# CITY OF ALBUQUERQUE

Planning Department

RE: **Lot 1 Block 5, S.A.D. 227**  
**Unser Cliffs Subdivision**  
**6524 Onyx Ct. NW**  
**Grading and Drainage Plan**  
**Engineers Stamp Date 10-24-18 (E10D053)**

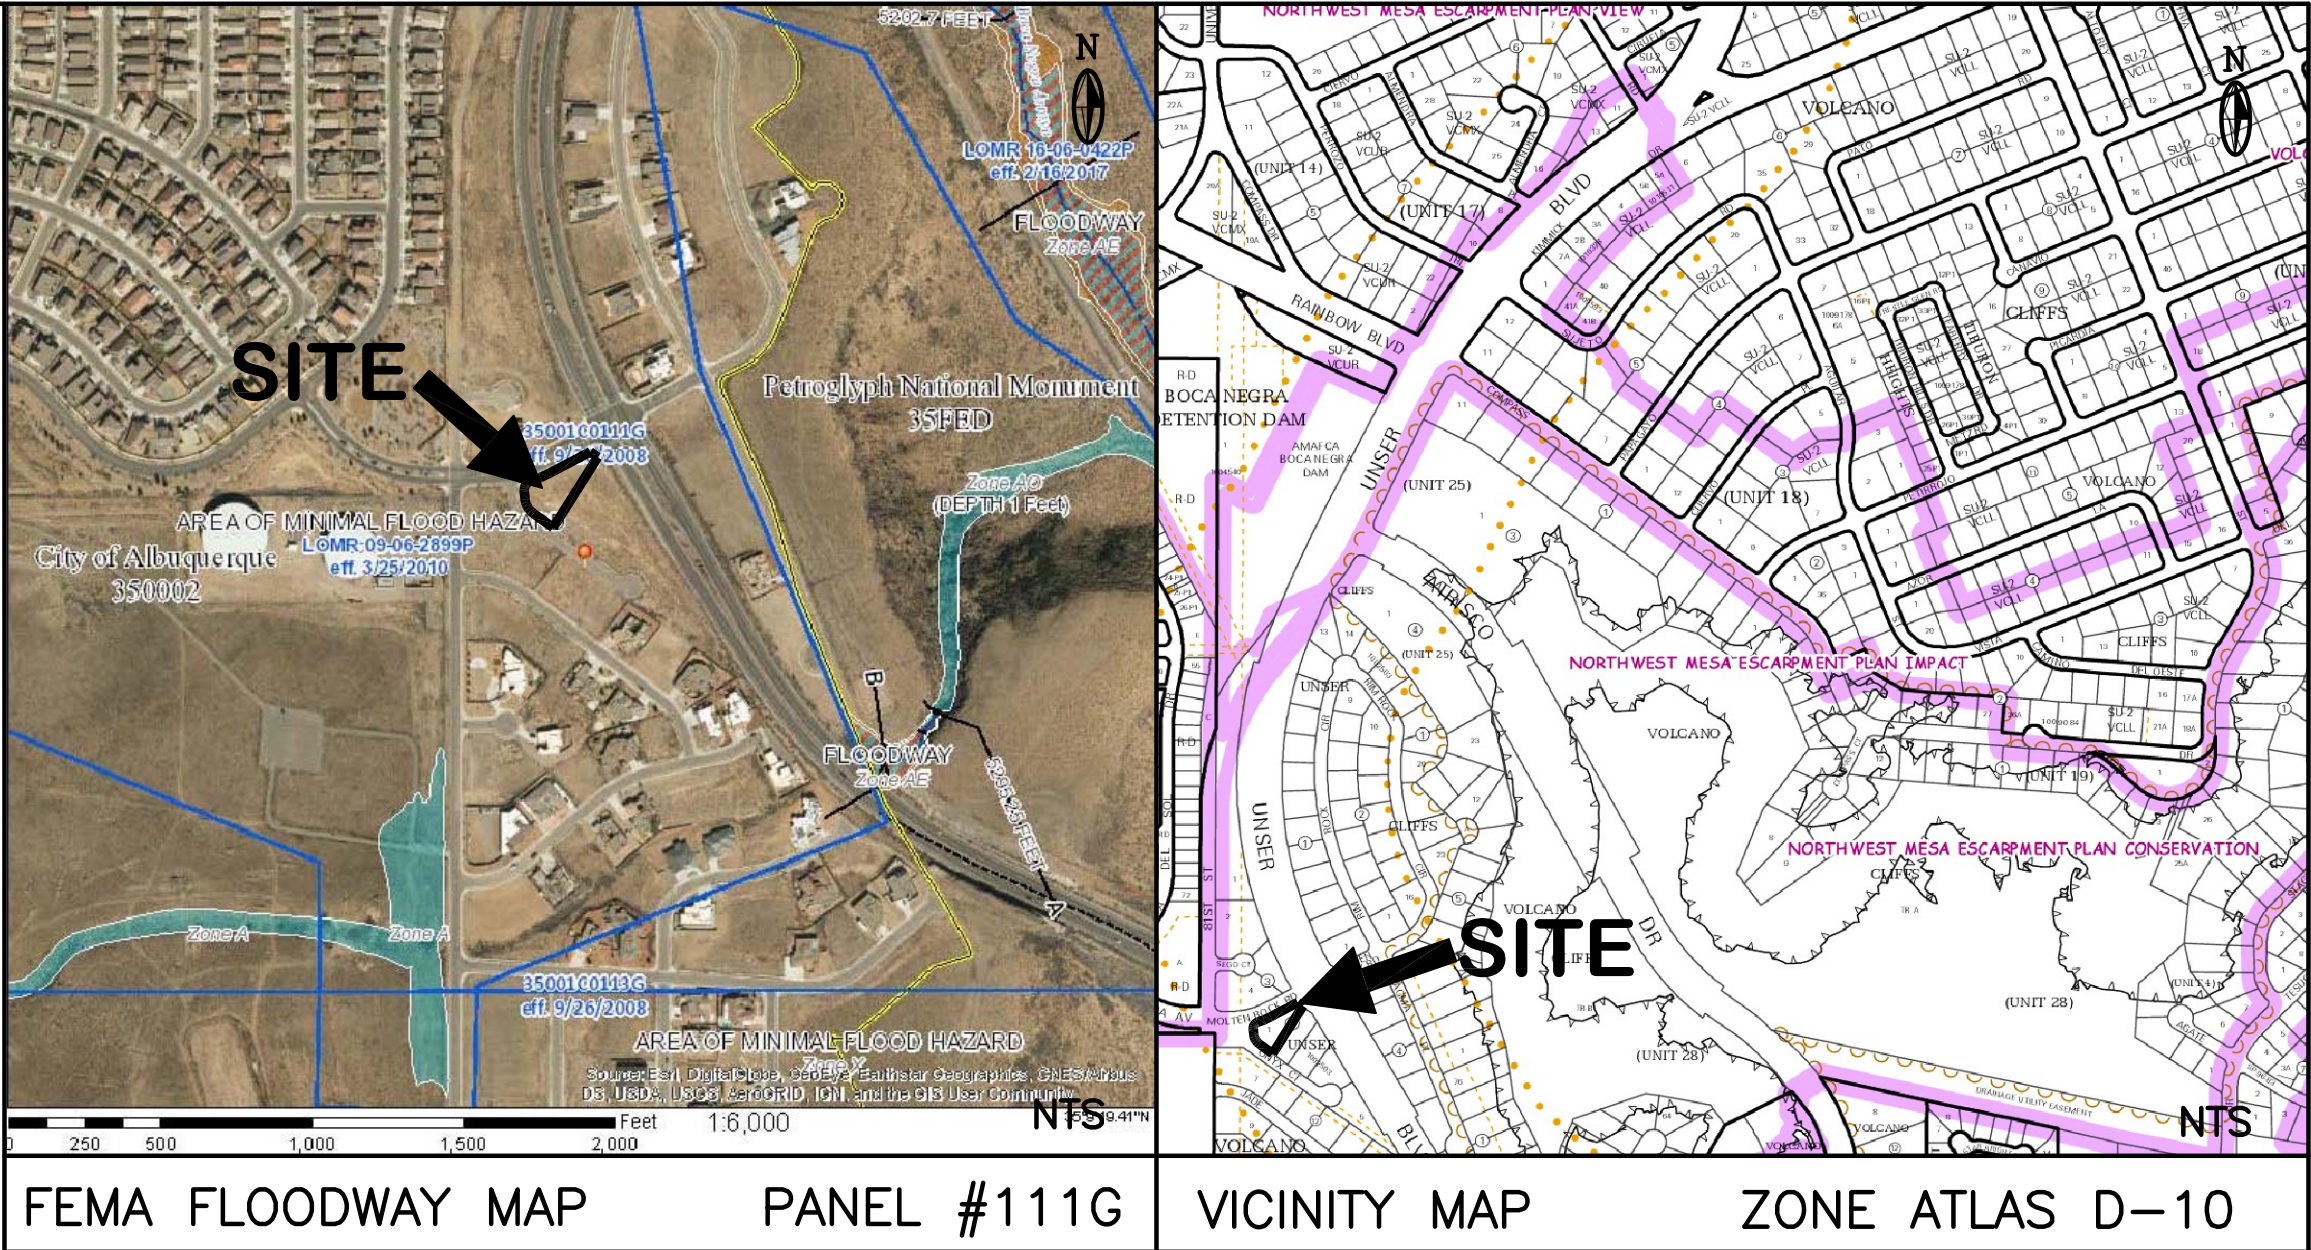
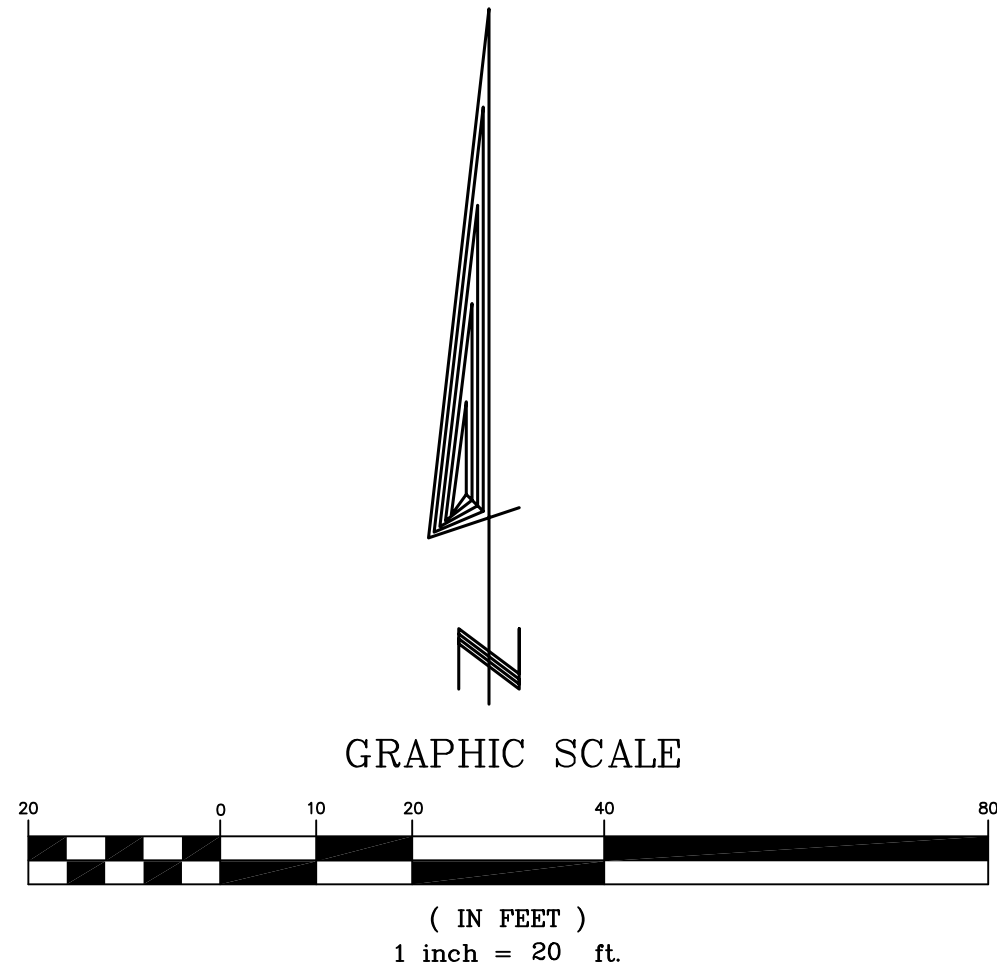
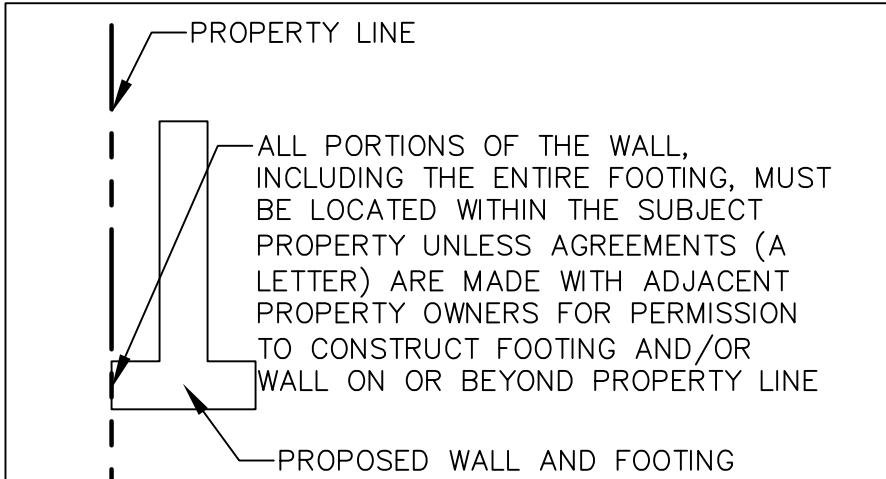
- Direct all flows to exit onto Onyx Ct. through a sediment capture pond.
- Cross lot drainage is not required; remove the turn blocks on the eastern garden wall.
- Remove the 7' PUE on the Molten Rock Rd. side.
